Application for a Non-Material Amendment Following a Grant of Planning Permission

Internal alterations to move disabled access room to ground floor with accessible en-suite, with single storey extension to rear to form utility and kitchen area

23/01373/FUL

change window proposed in the gable wall of the extension to the utility room to a disabled access door with ramped access

DRAWING No
A507 - L - 02

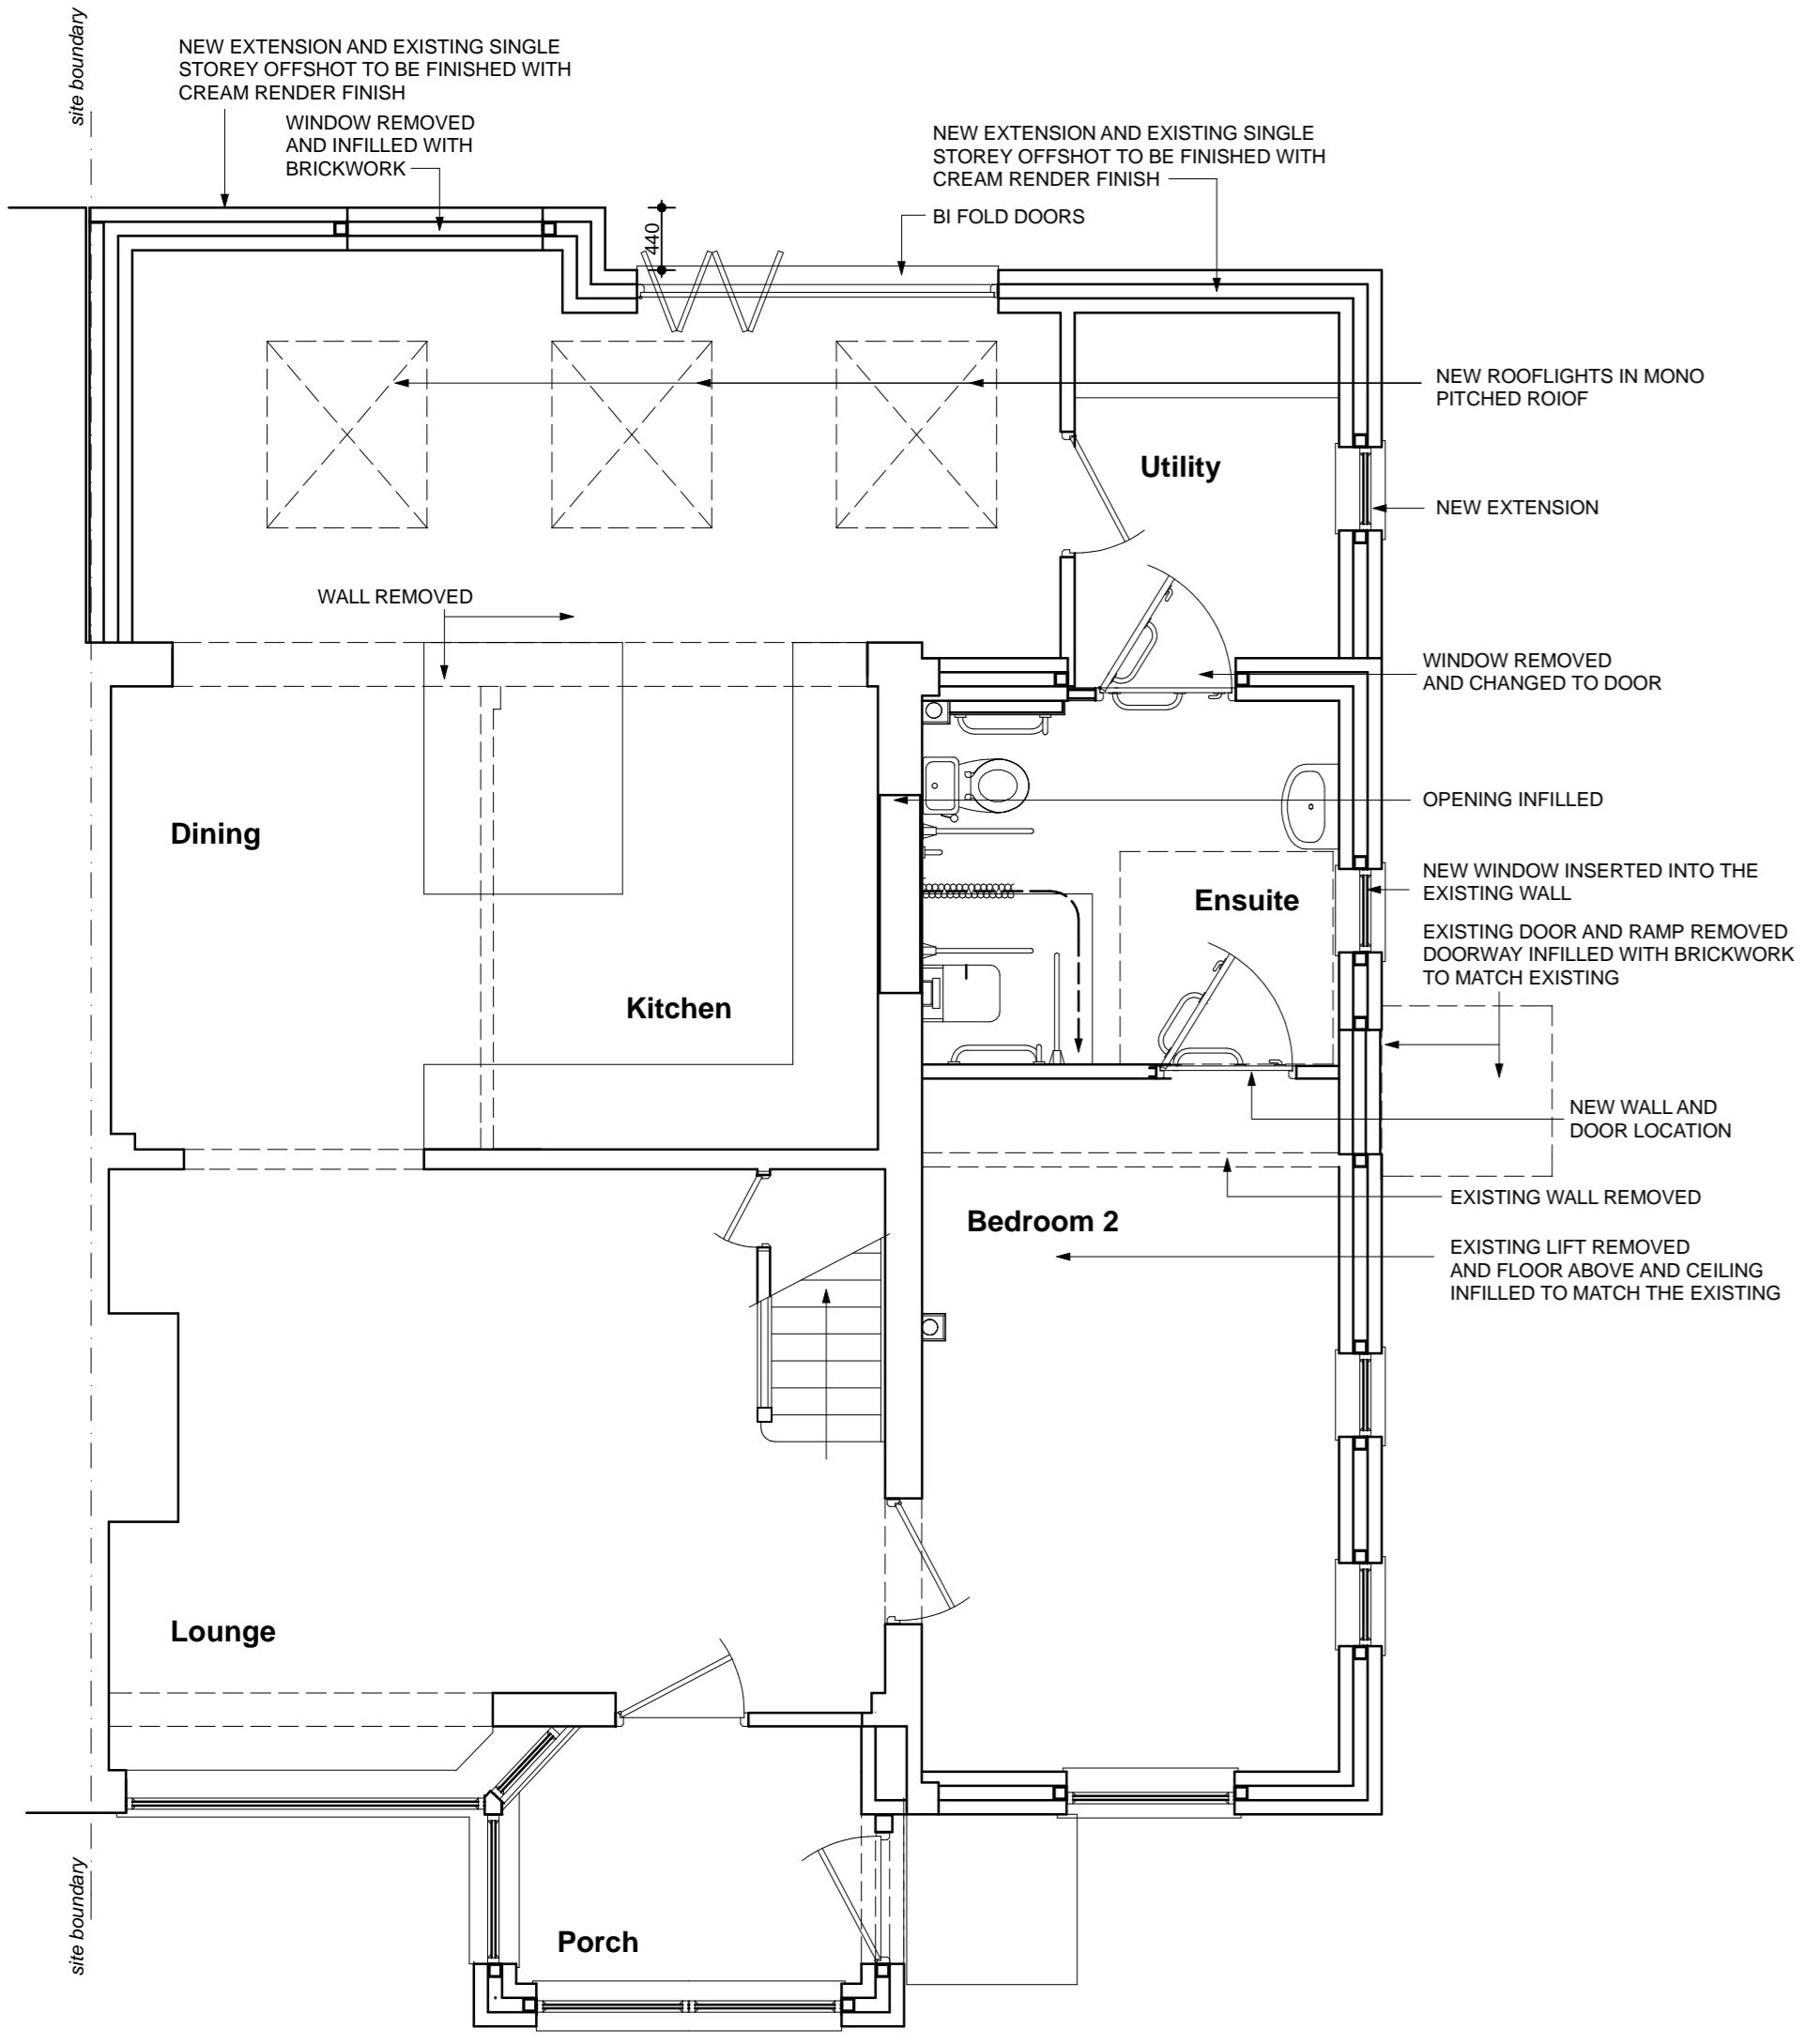
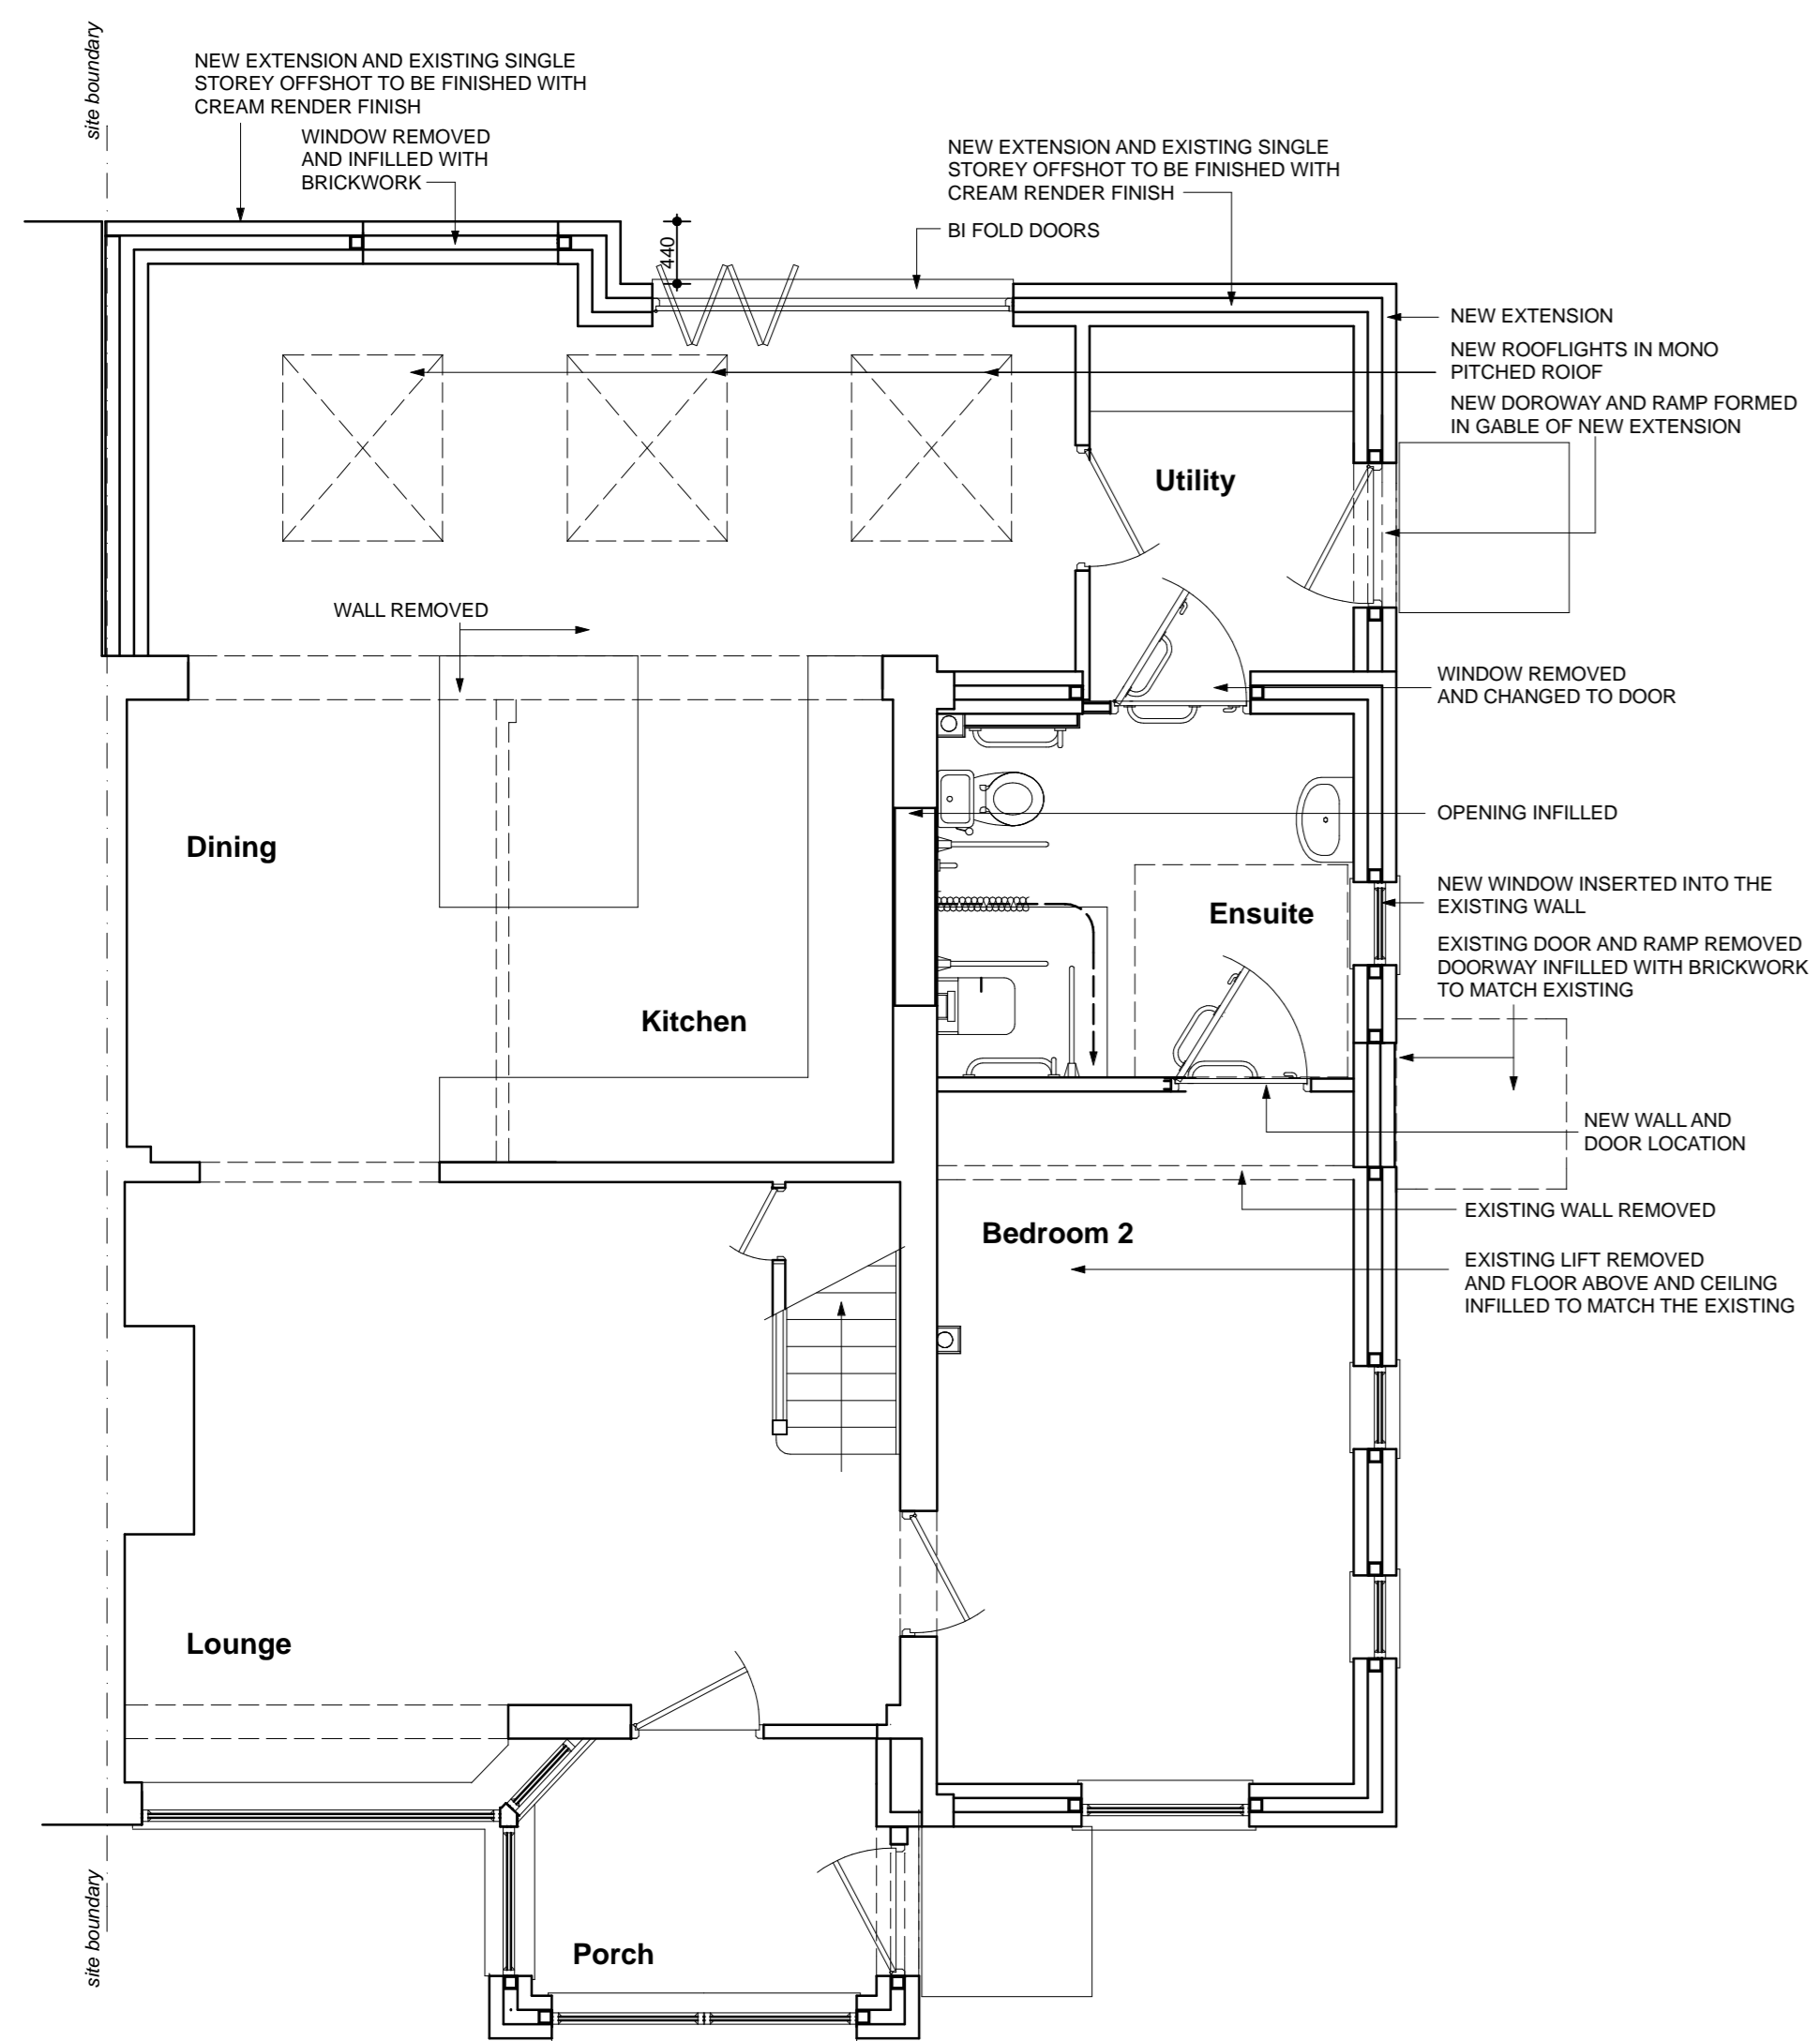
After review the applicant considers that a more direct wheelchair accessible entrance adjacent to where the cars are located would be more practical
